From: Anita Gardner
Sent: 15 August 2018 19:04
To: Planning.Responses
Subject: FW: LU/191/18/DOC

From: Colin Giddings
Sent: 25 July 2018 14:03
To: Anita Gardner
Subject: LU/191/18/DOC

I've had a quick look at the conditions discharge documents which relate to EH/Site Licensing and would comment as follows:

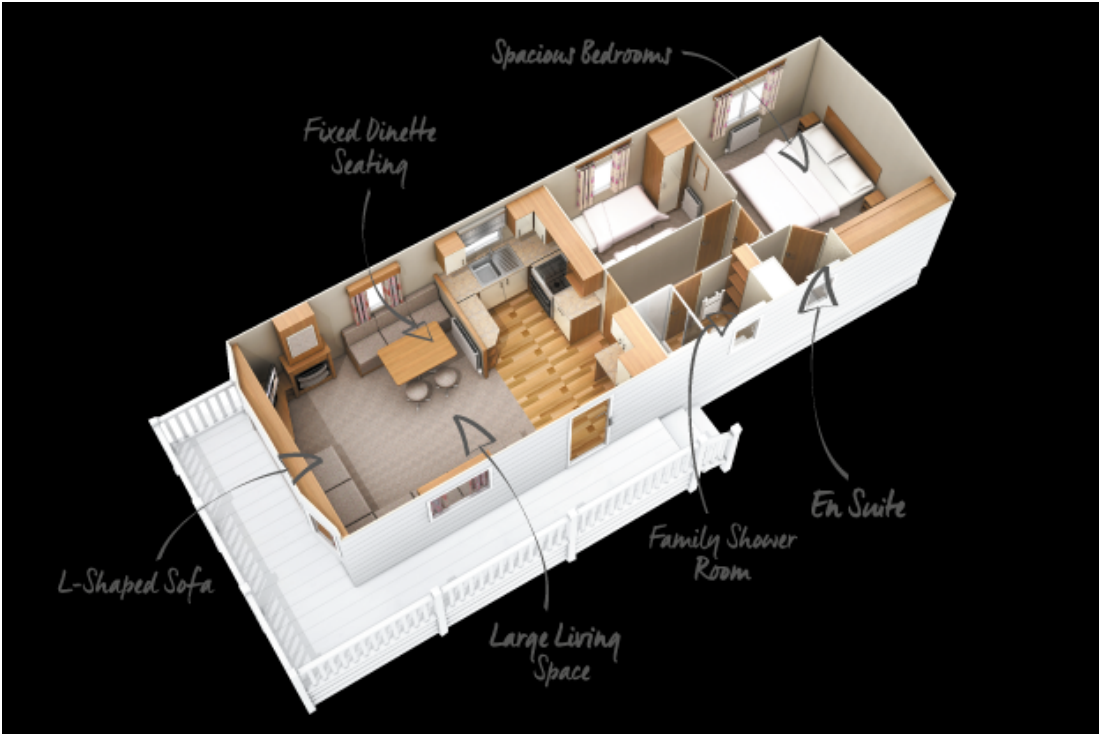
Condition 8 – Cycle Store

There is mention of a plan for the proposed wooden structure but I have not had sight of this. The site will need to comply with spacing and safety standards when in operation. Without details of the proposed structure I cannot comment further.

There has been full drawings of the wooden shed, this particular one is sprayed FireChief to give fire resistance. I trust this meets the points of concern.
